SSD_6603: Site 68, Sydney Olympic Park

Response to Submissions

March 2015

Figure 9: Site 68 landscape plan showing location of bioretention systems

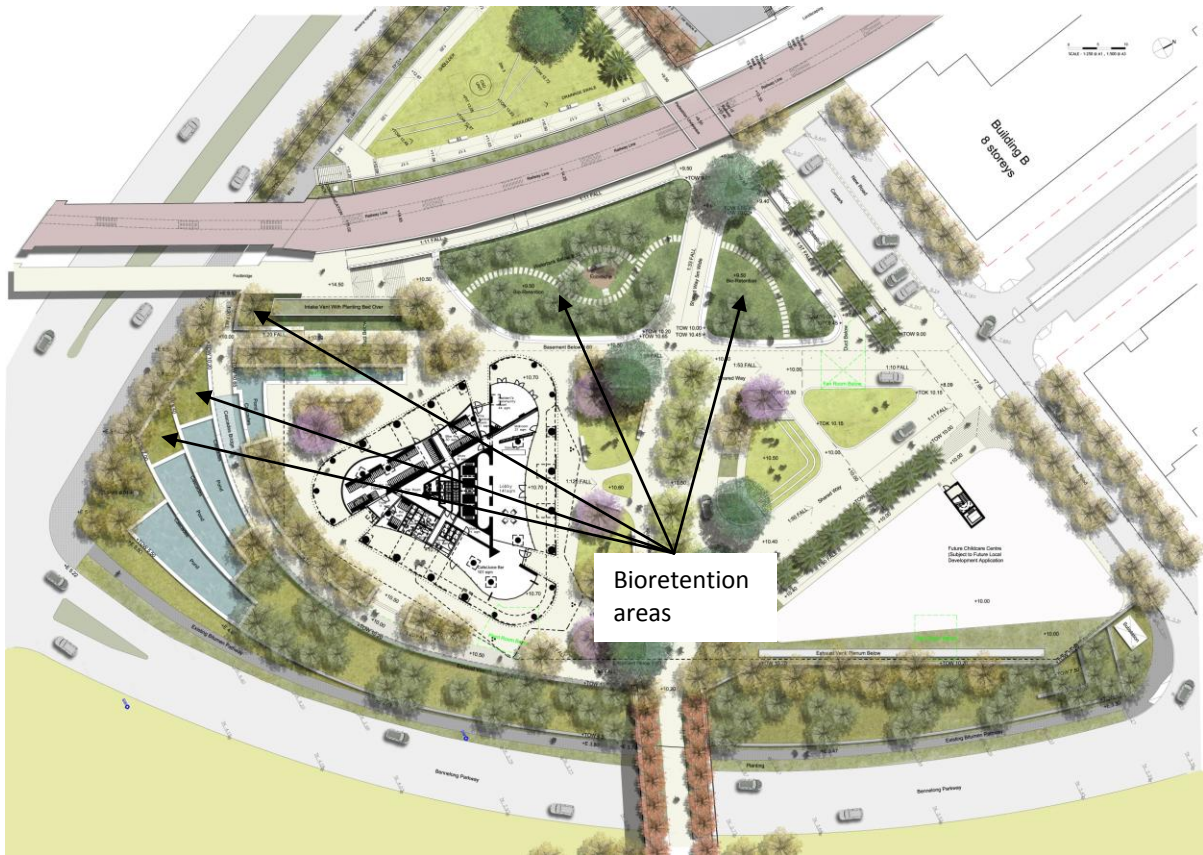
ISSUE	RESPONSE
<p>Stormwater Management:</p> <ol style="list-style-type: none"> 1. The stormwater system is to be designed so that the discharge flow rates into Bennelong Pond meets SOPA requirements. 2. The Applicant is to revise the Stormwater & Flooding Assessment Report including the Integrated Water Management Plan (Appendix Q) to address all aspects of SOPAs Stormwater Management and Water Sensitive Urban Design (SMWSUD) Policy. 3. The Applicant be required to revise the Stormwater & Flooding Assessment Report (Appendix Q) to address the longer term ecological impacts on Bennelong Pond arising from the increased water quantity outflows from Site 68 during larger storm events (refer Table 5) and ways to manage or mitigate these impacts e.g. the high flow bypass. 4. The Applicant provides a maintenance and performance testing regime for the new treatment system prior to approval of the DA (consistent with the SOPA SMWSUD Policy). 	<p>Refer to the Stormwater Report prepared by Alluvium and provided at Appendix G.</p>

Summary:	Quantity	Percentage
Total Units with 3 Hours Minimum:	251	68%
Total Units with 2 Hours Minimum:	288	78%

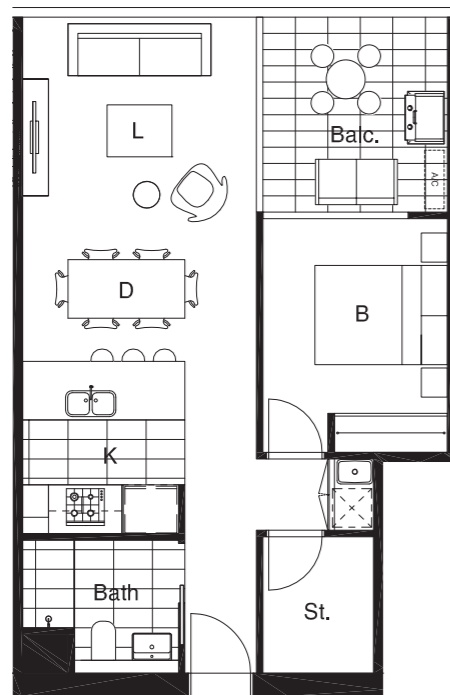
ISSUE	RESPONSE
<p>Solar Access: The proposed development provides an assessment of solar access between 9am and 4pm. The proposed development should provide an assessment between 9am and 3pm (as per MP 2030) and provide justification if the 70% target is not achieved.</p>	<p>68% of residential apartments achieve 3 hours of solar access between 9am and 4pm on 22nd June. 78% of residential apartments achieve 2 hours of solar access between 9am and 4pm on 22nd June.</p> <p>42% of residential apartments achieve 3 hours of solar access between 9am and 3pm on 22nd June. 60% of residential apartments achieve 2 hours of solar access between 9am and 3pm on 22nd June.</p> <p>Consistent with the principles set out the RFDC, the design seeks to maximise the number of apartments receiving direct sunlight in midwinter to living rooms and balconies. These spaces are given priority and are located at the building's façade to ensure solar access to both spaces. The plan geometry is such that the north and west oriented apartments receive 3 hours of solar access between 9am and 4pm, while the remaining apartments receive the highest quality views.</p> <p>It is argued that Site 68 is situated within a dense urban area and as such the two hour provision, as described in the RFDC is acceptable. This is emphasised by the proposed future use of the Parkview Precinct as described within the Sydney Olympic Park Master Plan 2030, which states: <i>"Its existing industrial and commercial uses will progressively give way to a higher density, mixed use precinct incorporating community, educational, commercial and residential uses to create a compact urban neighbourhood with a vibrant and leafy street character."</i></p> <p>Furthermore, as indicated on the shadow diagrams provided at Appendix A, the adjacent residential tower on Site 3 overshadows the proposed development for one hour between 2pm and 3pm on 22 June. This further emphasises that the site is located in a precinct with a developing character of high density urban form and as such it is considered that the area constitutes a dense urban form and the lower standard of solar access should be applied.</p>

# 11.0 SAFETY + SECURITY

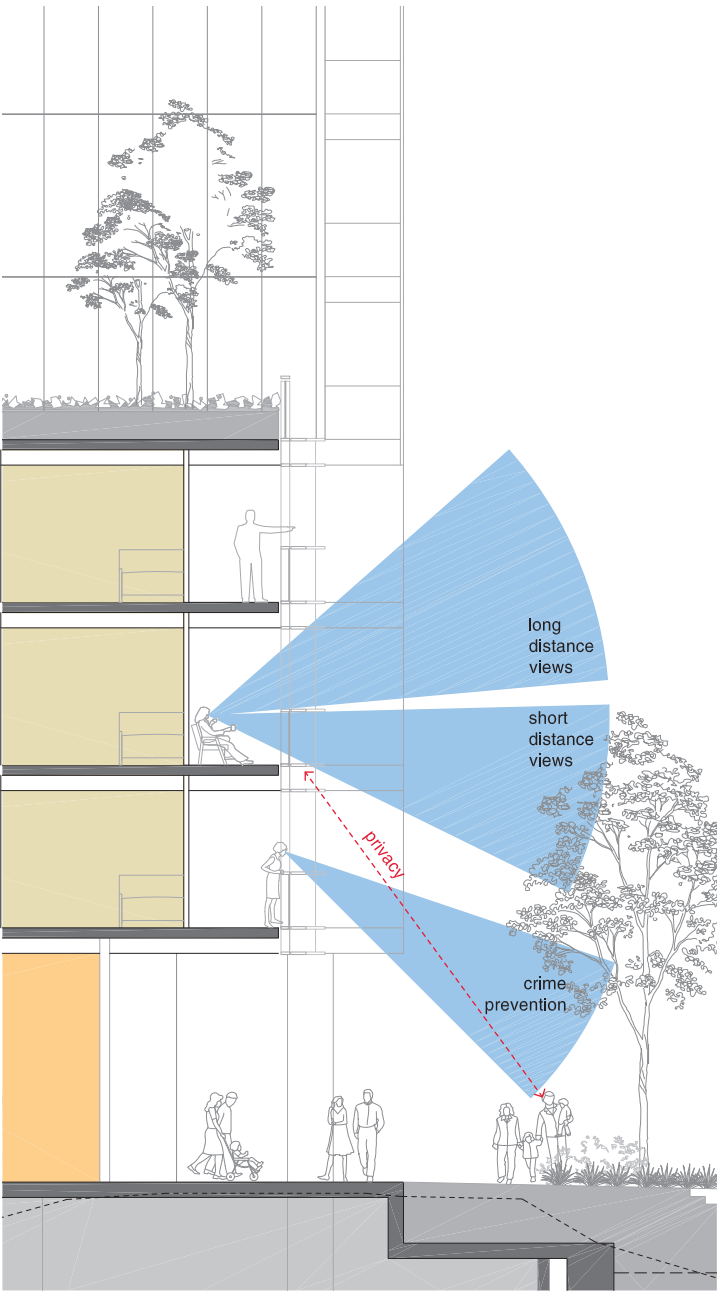
<p>Crime Prevention through Environmental Design: There is little passive surveillance to the ground level of the proposed development and this is considered an issue. It is not clear from the documentation provided whether the proposed planting consists of low ground covers with tree planting. The location of tree planting should ensure that clear and unobstructed sight lines are retained for passive surveillance of the ground floors of the new building, as well as ensuring any new planting discourages antisocial behaviour.</p>	<p>Details of the proposed ground level landscape treatment are provided within the Landscape Design Report at Appendix B. In summary, the proposed planting consists of low ground covers and trees with trunks that extend at least 3m above the ground.</p> <p>Trees have been positioned to ensure clear sightlines are retained.</p>
